Quality Audit – Stage 1

Shanganagh Castle Residential Neighbourhood

On behalf of Dún Laoghaire-Rathdown County Council

January 2020

TYPICAL PLAN OF DROPPED KERB (DK) SCALE 1:20

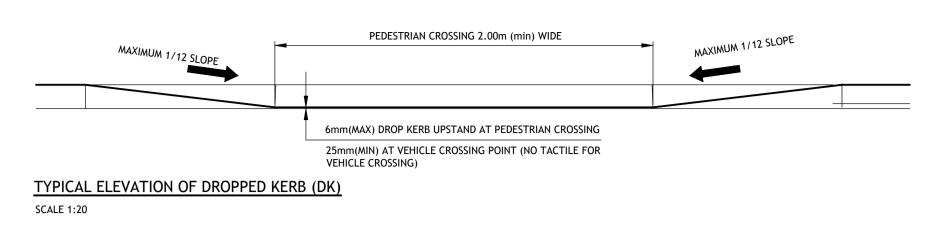
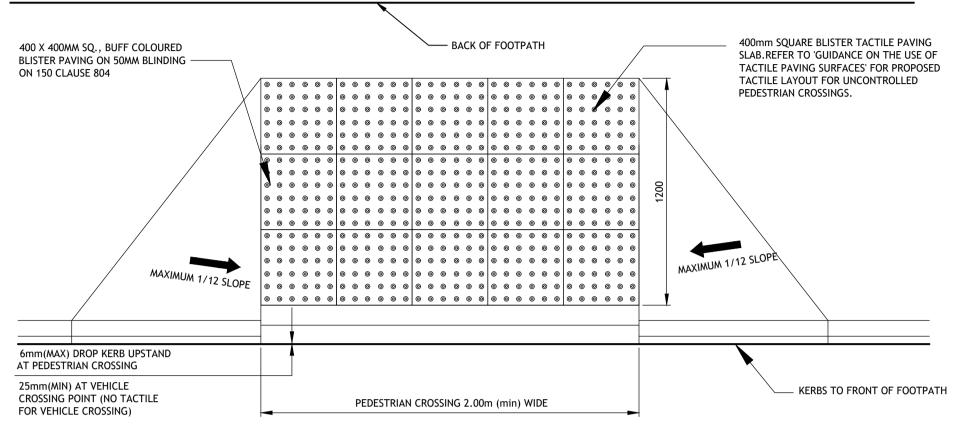
Ref	Feature	Conforms	Access Comment	Action
4.4.1	Is the crossing type appropriate for the location?	Yes		None required
4.4.2	Does the controlled crossing have tactile paving in compliance with the standards and red in colour	No	Tactile 'L' shown incorrectly, See Fig 4.4.1 below	Design Team update layout

4.2.14	Y	Y	Item accommodated in revised drawings	
4.2.15	Y	Y		
4.2.16	Y	Y		
4.2.17	Y	Y	Different surface finishes and floor signage to be provided.	
4.2.18	Y	Y

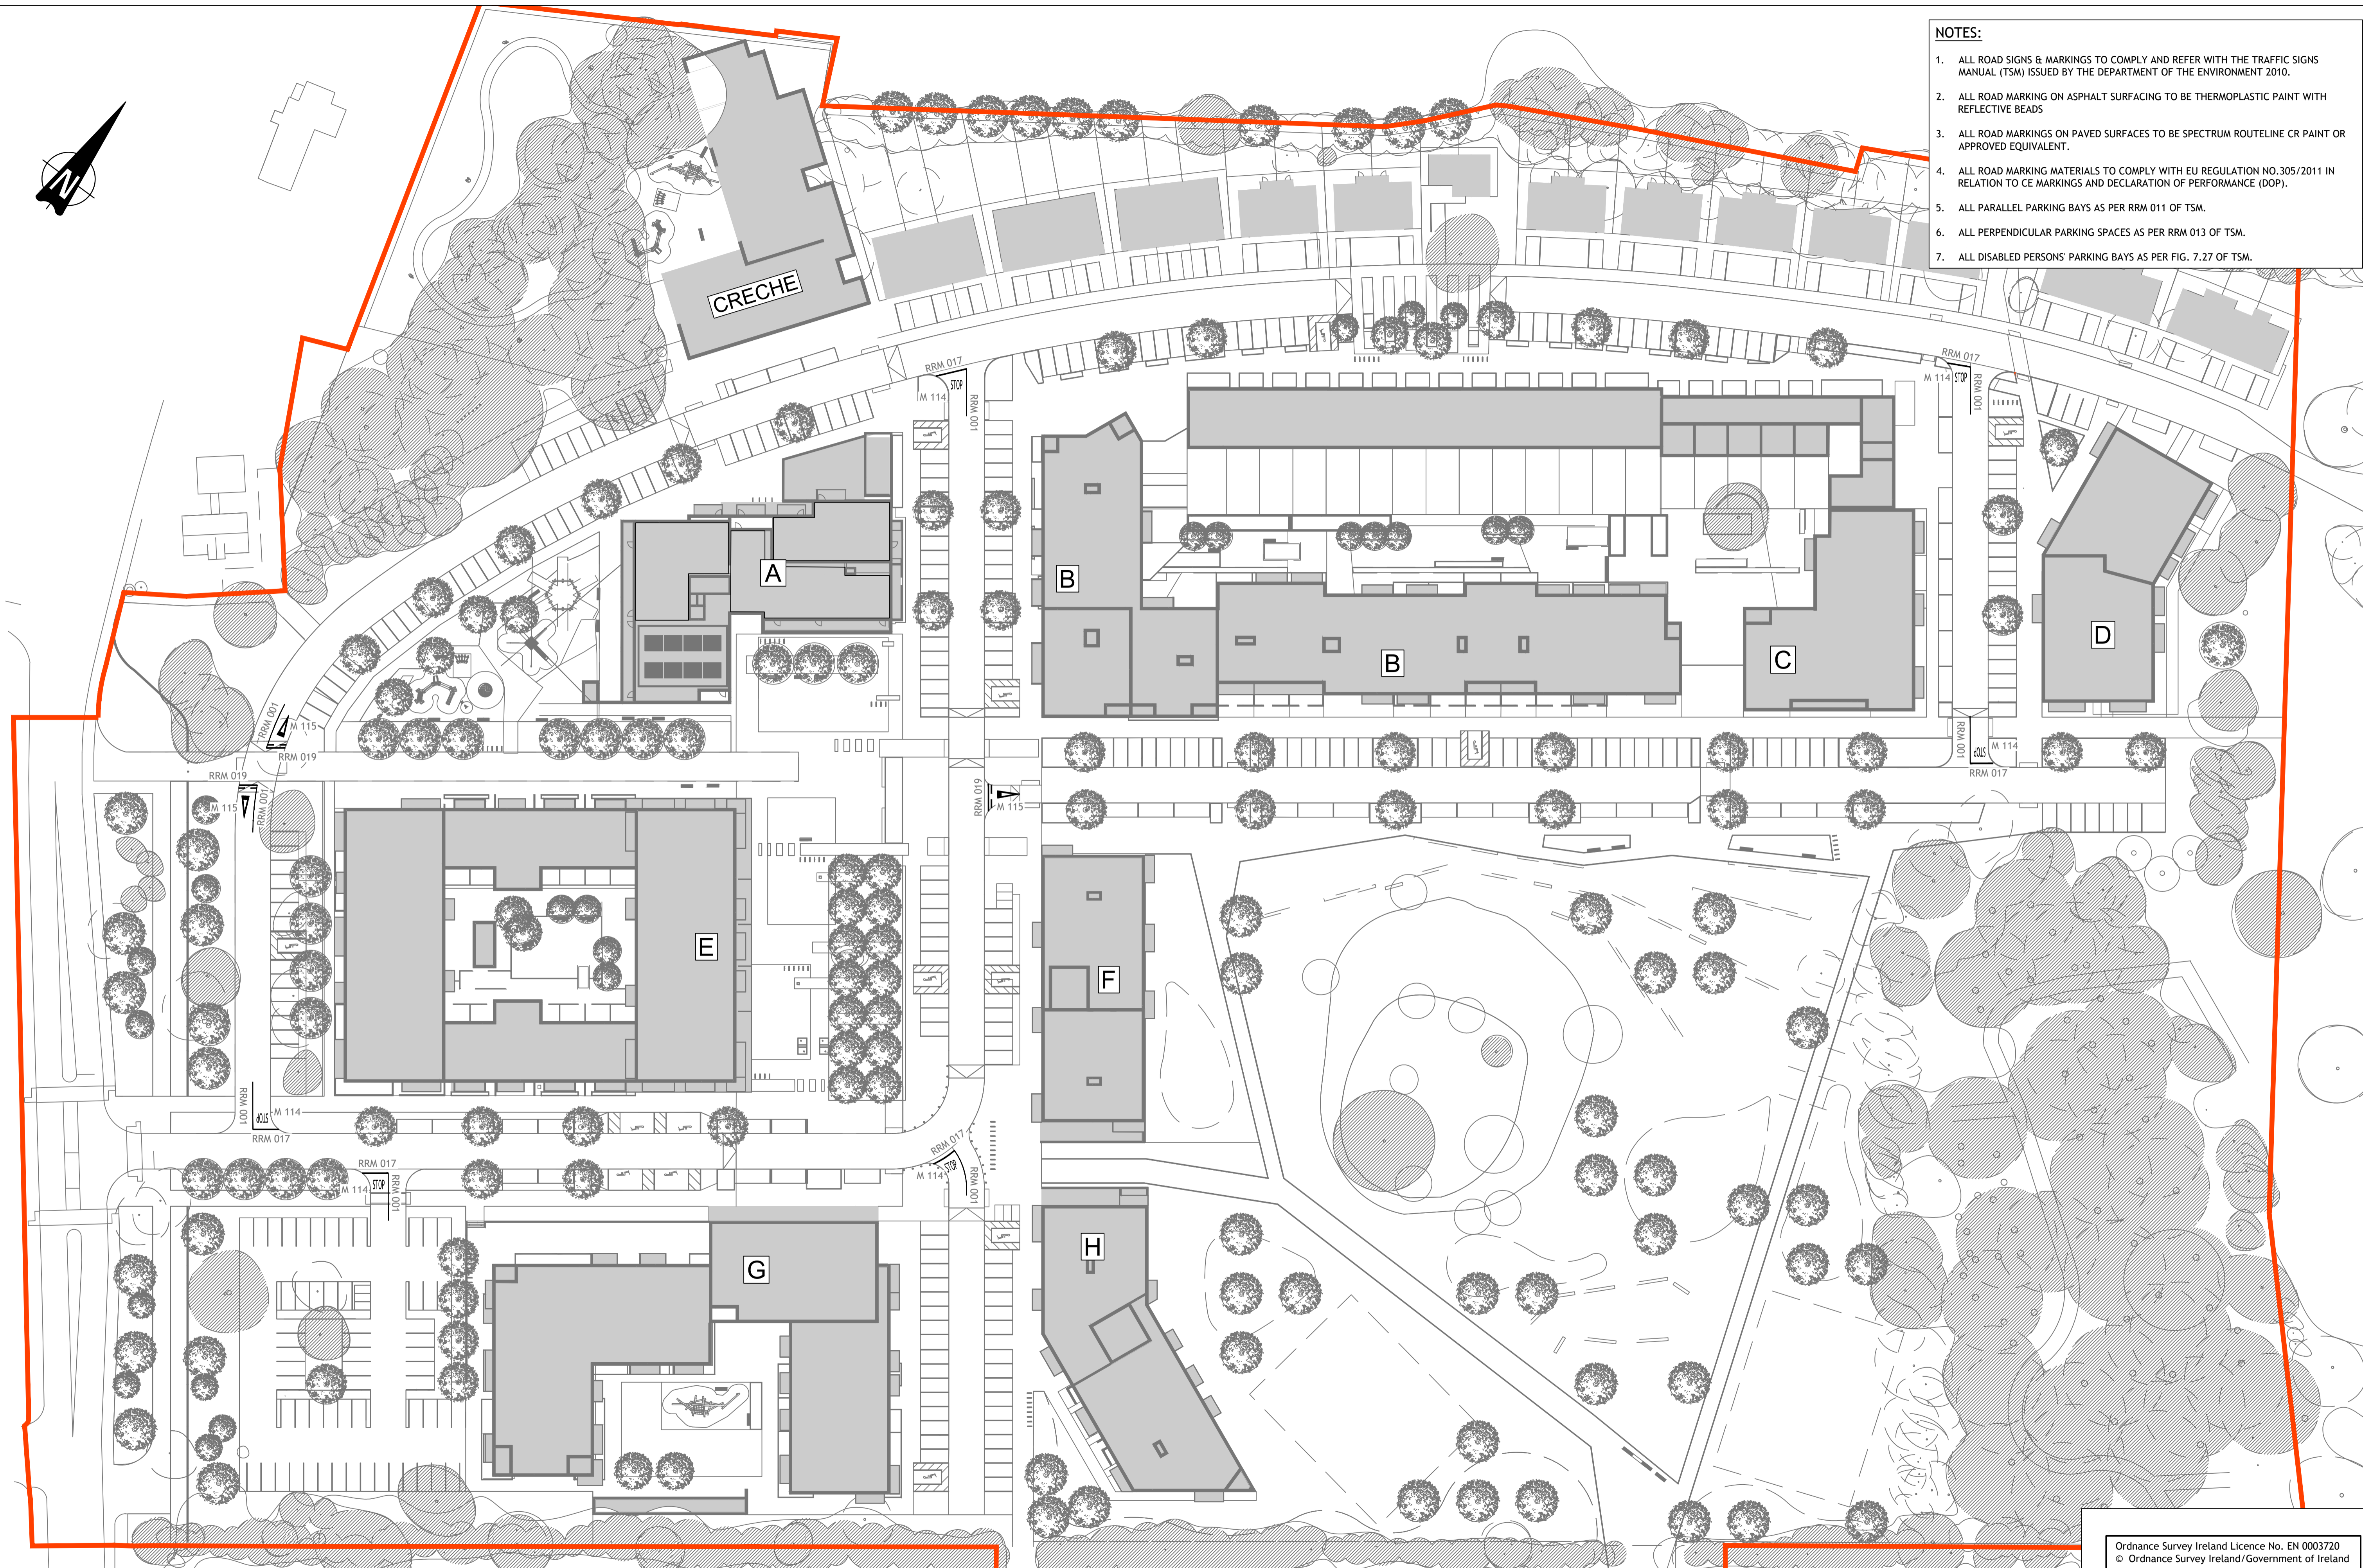
Problem: No priority control is shown where cyclists encounter Street 2 or the footpath on the R119.

Recommendation: Provide yield symbols for the traffic that should yield.
